Application Ref:	3/2025/0874			 Ribble Valley Borough Council www.ribblevalley.gov.uk				
Date Inspected:	28/01/26	Site Notice:	28/01/26					
Officer:	LW							
DELEGATED ITEM FILE REPORT:					APPROVAL

Development Description:	Proposed first floor extension, balcony and front porch.
Site Address/Location:	Woodlands Farm, Hothersall Lane, Hothersall, PR3 2XB.

1 PROPOSED SITE PLAN
1 : 200

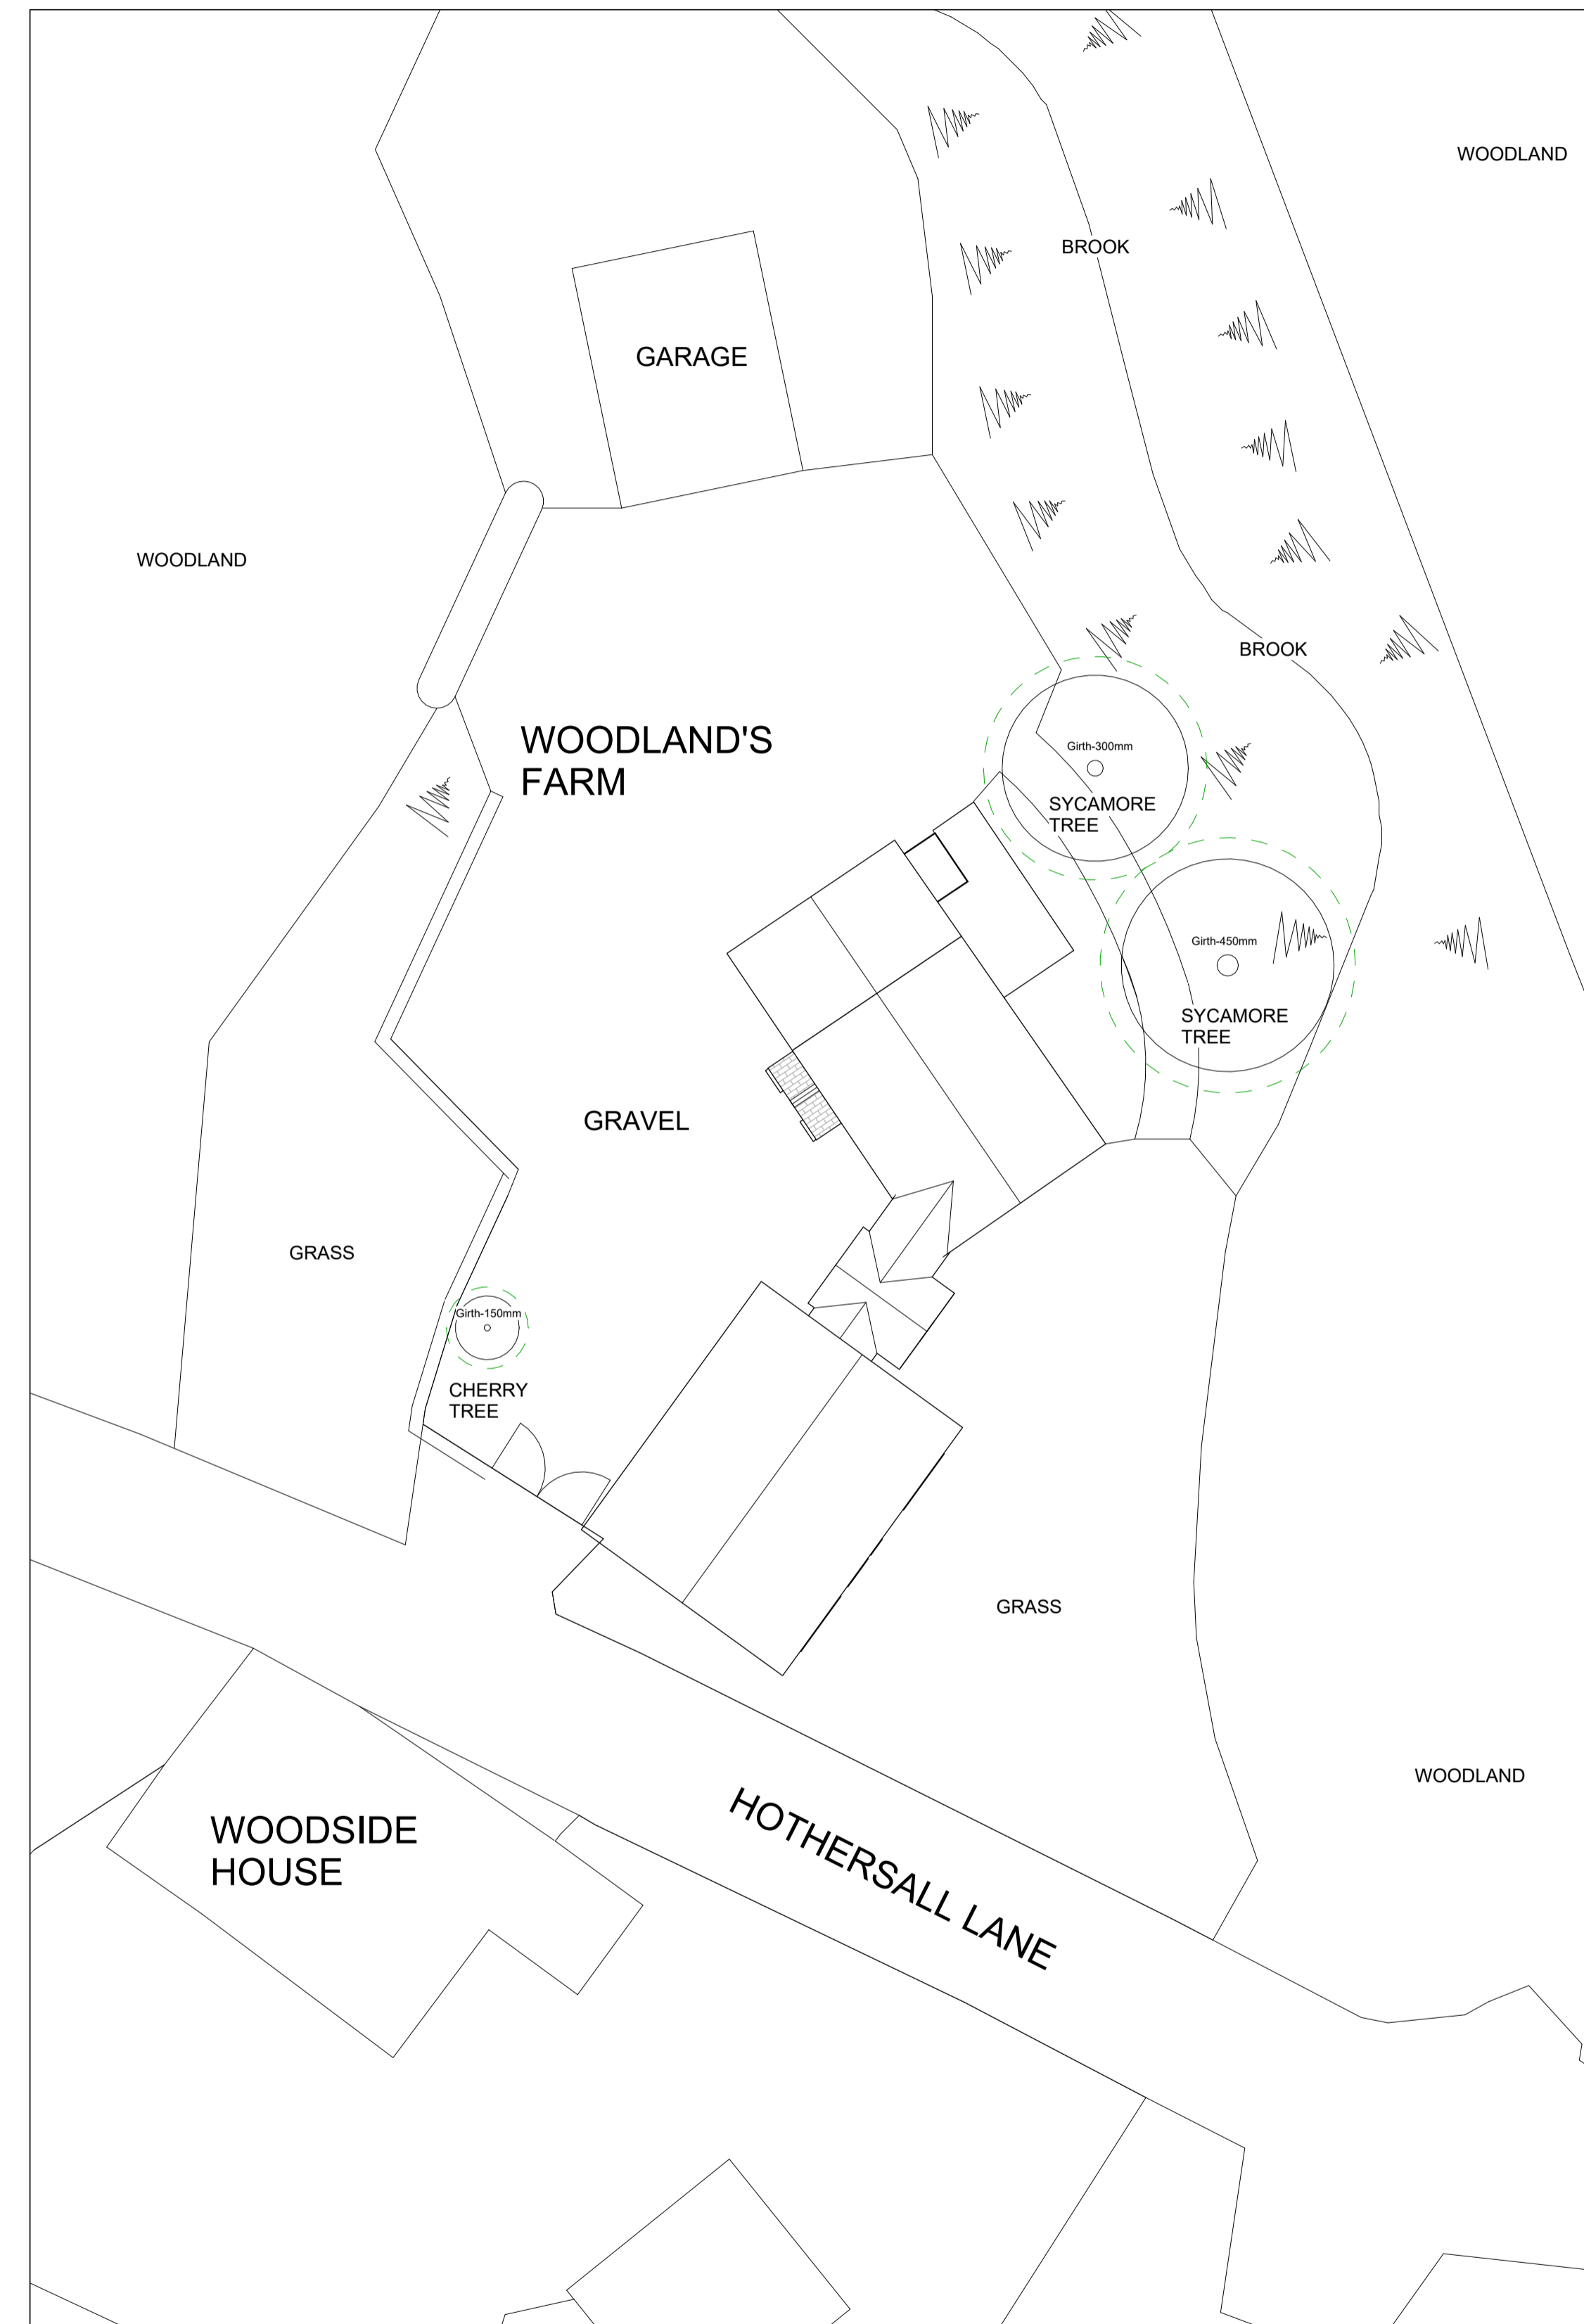
The application site is bordered the north and east by an area of woodland which forms Leece's Wood Biological Heritage Site (BHS). Whilst it is not considered that the proposed development would result in any direct impacts upon these trees or the wider BHS, a condition can be imposed requiring all retained trees to be protected during construction works in order to mitigate the risk of any adverse harm.

Part of the proposal site is at risk of surface water flooding; however, the proposed development itself would not be sited on land subject to increased risk of flooding. In addition to this, the proposal relates to a first-floor extension and relatively small-scale porch, and therefore the resultant impact on flood risk would be limited.
